4 December, 2017

Amended Concept Proposal – Cockle Bay Wharf Redevelopment

Figure 12 - Reduction in scale

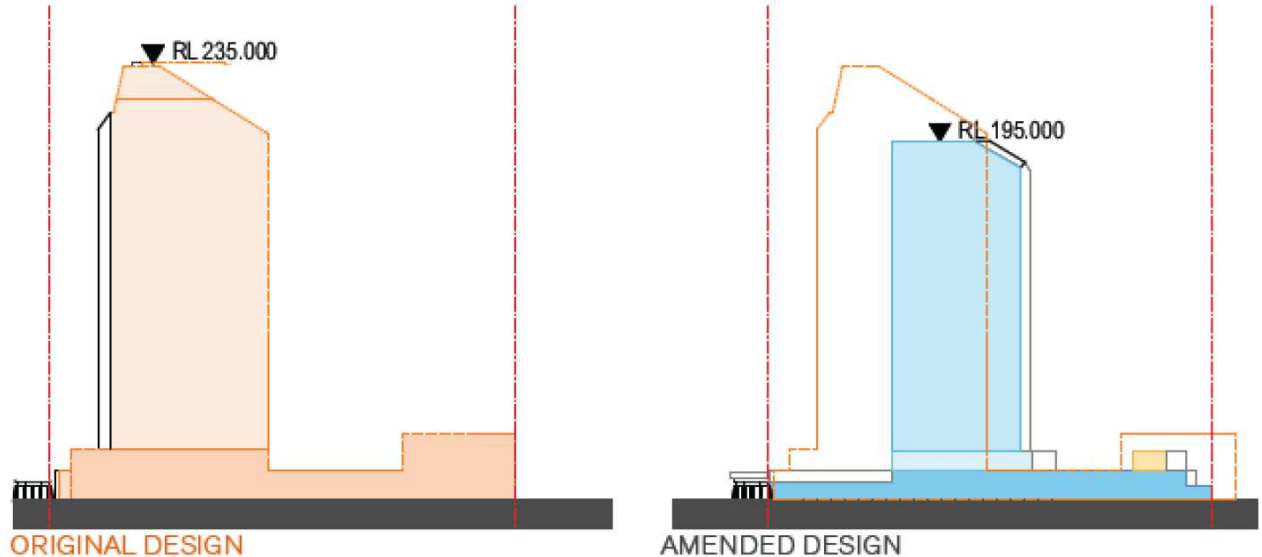
Scale of Project – We recommended the reduction of the building envelope of both the tower and the podium and note that the tower has been reduced in bulk and by 40m in height in the amended plan. We also note that there is likely to be some overshadowing of the foreshore area between 9am and 11am, and of the Crescent Garden, with the likelihood of some shadowing impact on the future Town Hall Square. The perspectives provided still depict a tower significantly higher than adjacent buildings. The shadow diagrams are so poorly drafted that it is almost impossible to ascertain the impacts on facilities such as the children's playground, and on the water, including on winter mornings but there appears to be shadowing of the water between 9am and 11am. *We recommend a further reduction in the scale of the development with a height of no more than 35 storeys.*

Figure 10 - Relocation of tower

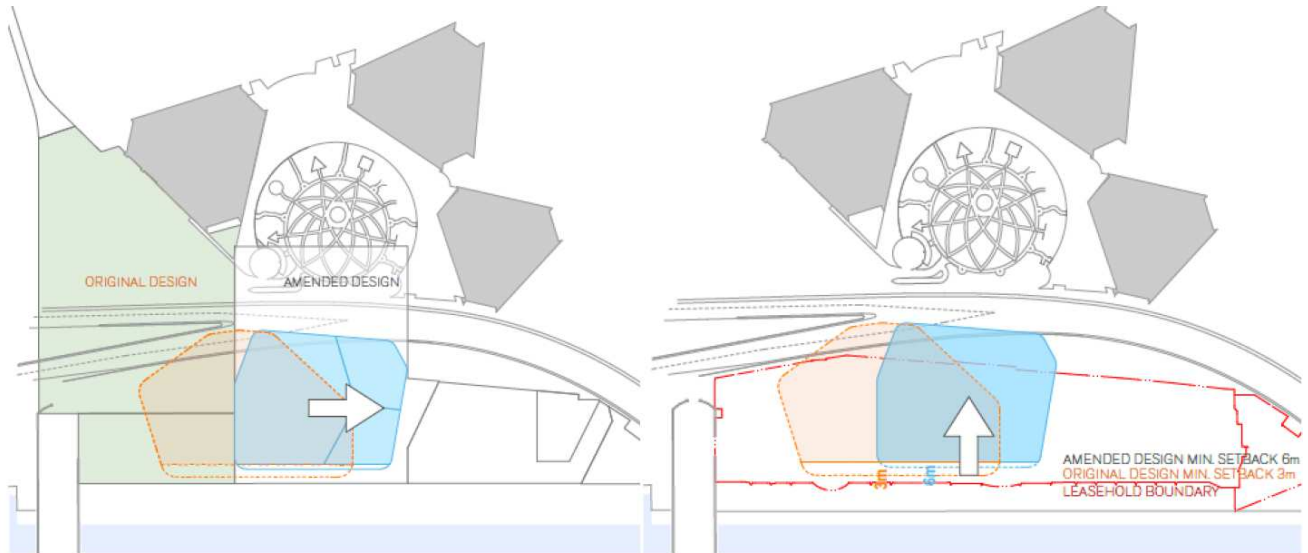
Building Placement – The amended plans have responded to concerns about the proximity of the tower to the end of the Pyrmont Bridge but the podium is still too close to the bridge. We note provision of additional
